re: **Grading Plan Review**  
**Proposed Residential Development**  
**Wateridge - Block 29 - Wanaki Road - Ottawa**

file: PG4965-MEMO.02

- ❑ Grading and Erosion and Sediment Control Plan, Project No. 119066-00, Drawing No. 119066-GR, Revision 2 dated September 13, 2019.

GRADING AND EROSION AND
SEDIMENT CONTROL PLAN

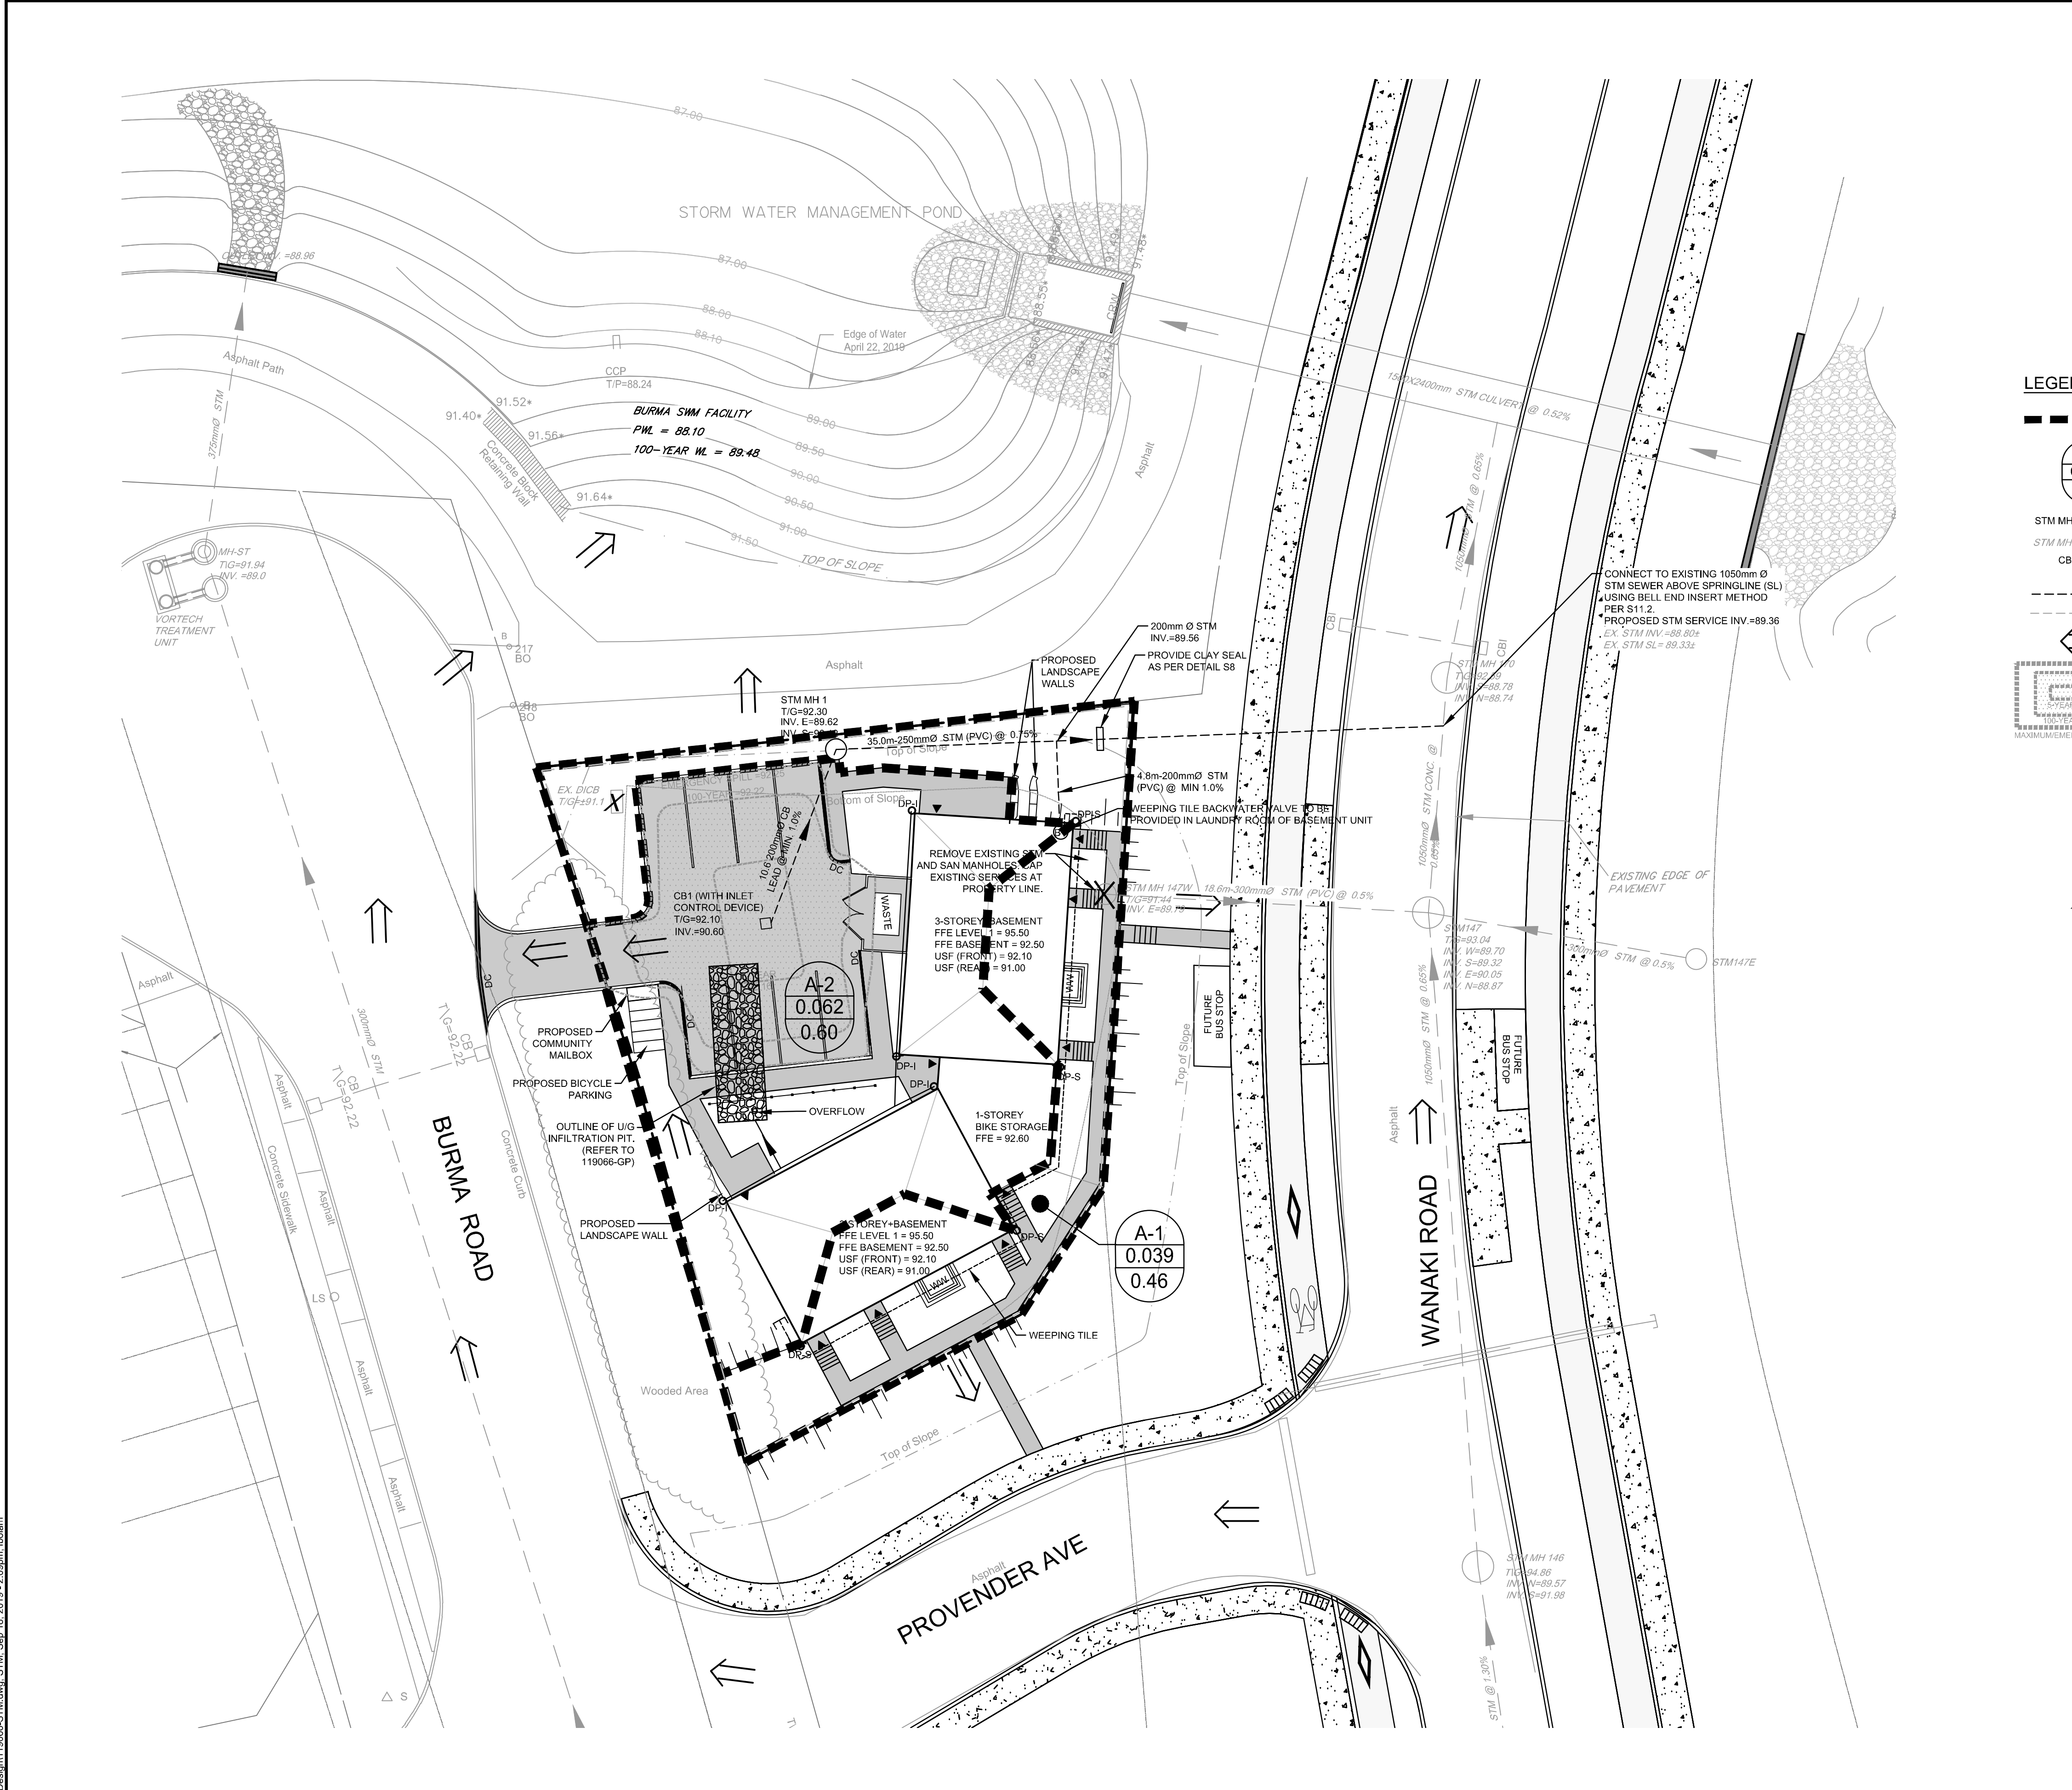
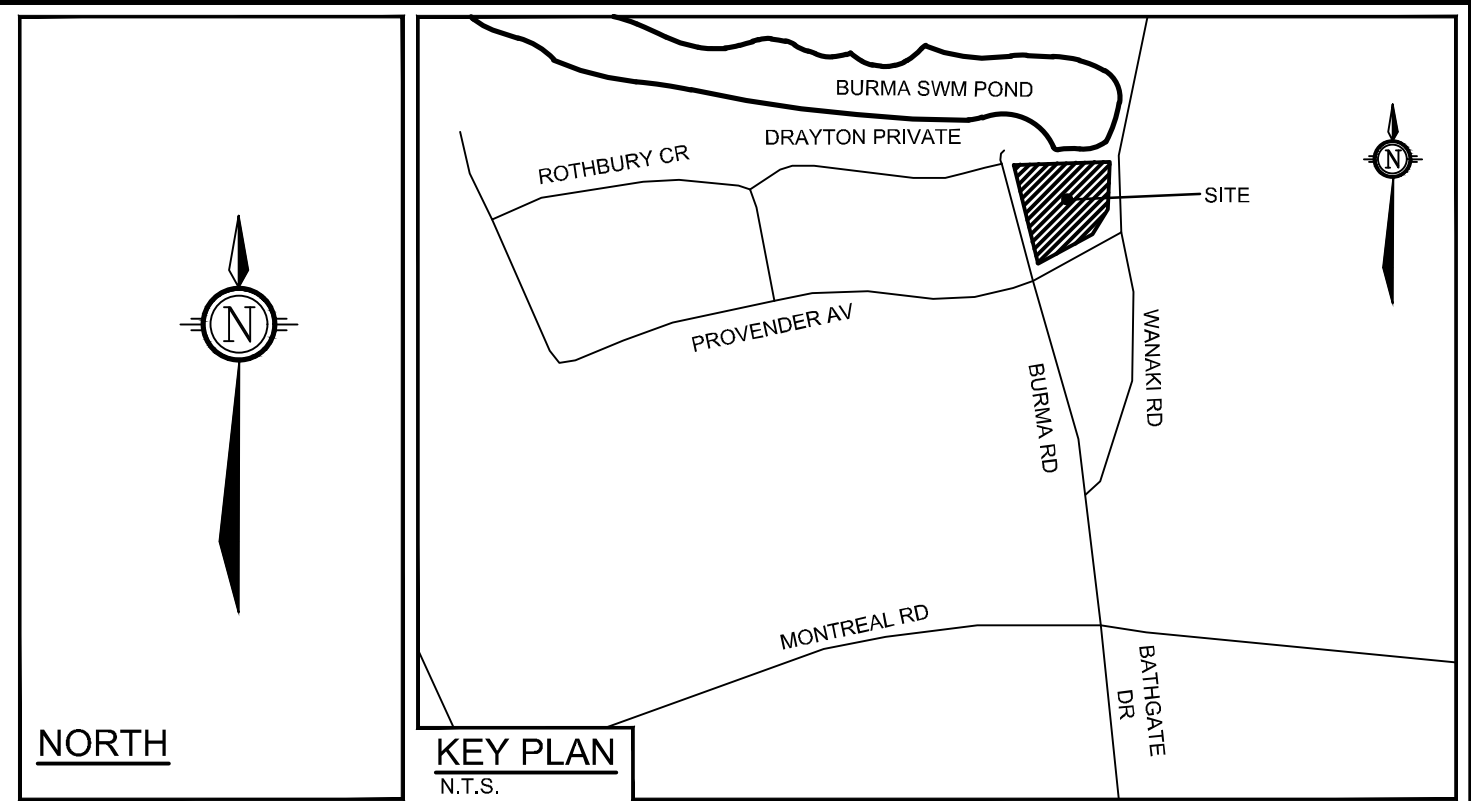
Based on our review of the above noted grading plans, the proposed grade raises for the proposed development of the aforementioned development are generally considered acceptable from a geotechnical perspective.

For design purposes, pad footings up to 5 m wide, and strip footings up to 3 m wide, placed on an undisturbed, hard to very stiff silty clay bearing surface designed using a bearing resistance value at serviceability limit states (SLS) of **150 kPa** and a factored bearing resistance value at ultimate limit states (ULS) of **225 kPa** is considered acceptable from a geotechnical perspective for the proposed buildings.

Furthermore, footings placed on an approved fill bearing surface can be designed using a bearing resistance value at SLS of **100 kPa** and a factored bearing resistance value at ULS of **175 kPa**. A geotechnical resistance factor of 0.5 was applied to the above noted bearing resistance values at ULS.

Footings designed with the provided bearing resistance value at SLS should have a total and differential settlement of 25 and 20 mm, respectively.

The bearing surface should be verified at the time of construction on a lot by lot basis to determine the appropriate serviceability resistance value.
